Tel: 01903 737756
Email: planning@arun.gov.uk
www.arun.gov.uk/planning
Please ask for: Ms Ella Summerfield
Email: ella.summerfield@terraquest.co.uk
Telephone: 0121 2341390
Our Ref: K/20/26/HH
Your Ref:
Date: 10th September 2026

Application for Planning Permission for Works or Extension to a Dwelling

Development: Construction of an outbuilding (garage).
Location: Panorama Golden Acre Kingston BN16 1QP

02 BLOCK PLAN
Scale 1:500

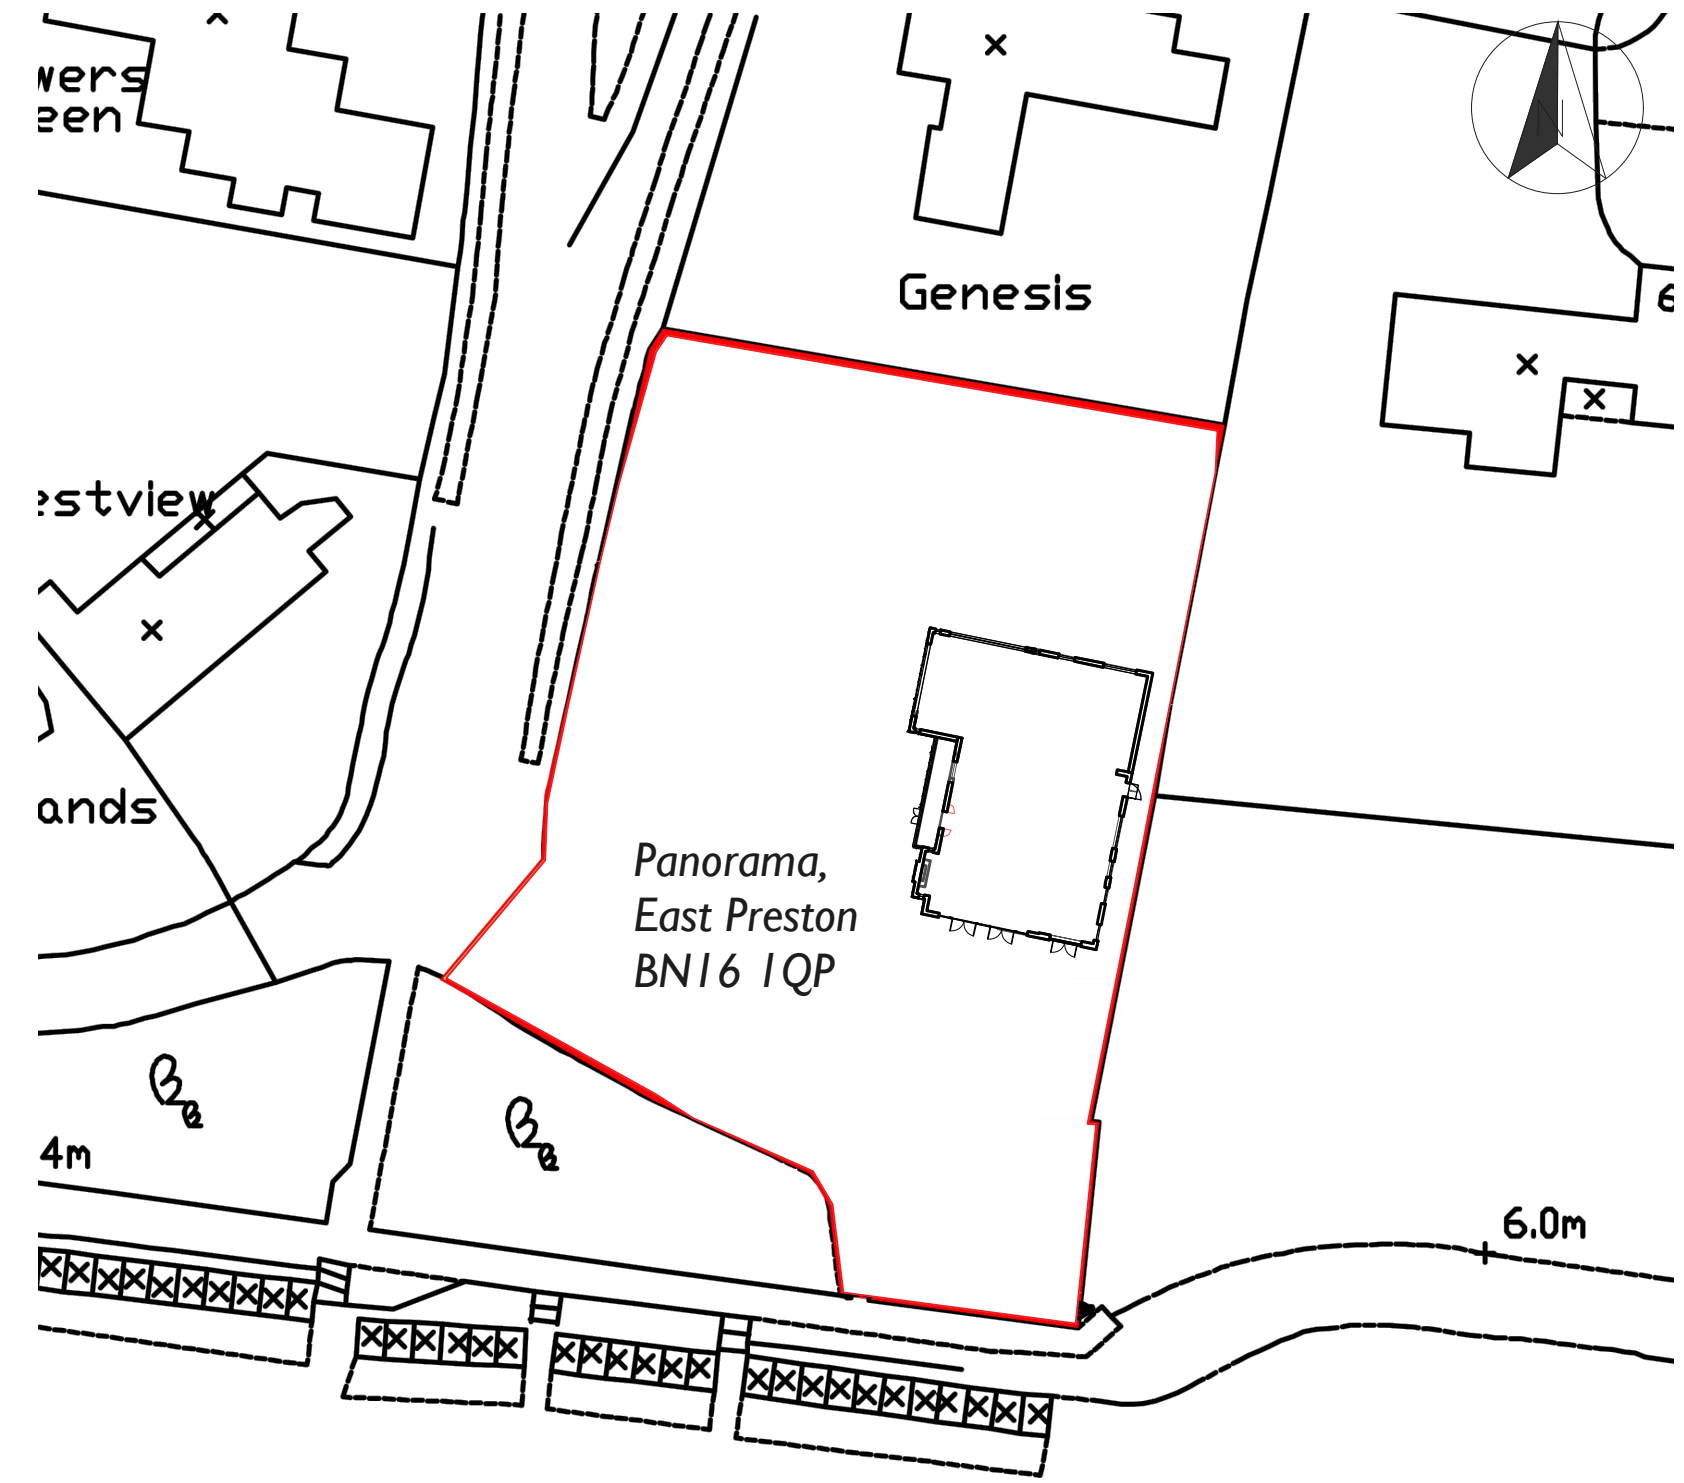
When comparing the existing and proposed block plans, there appears to be one conifer removed. The "trees and hedges" section in the application form will therefore need to be ticked yes.
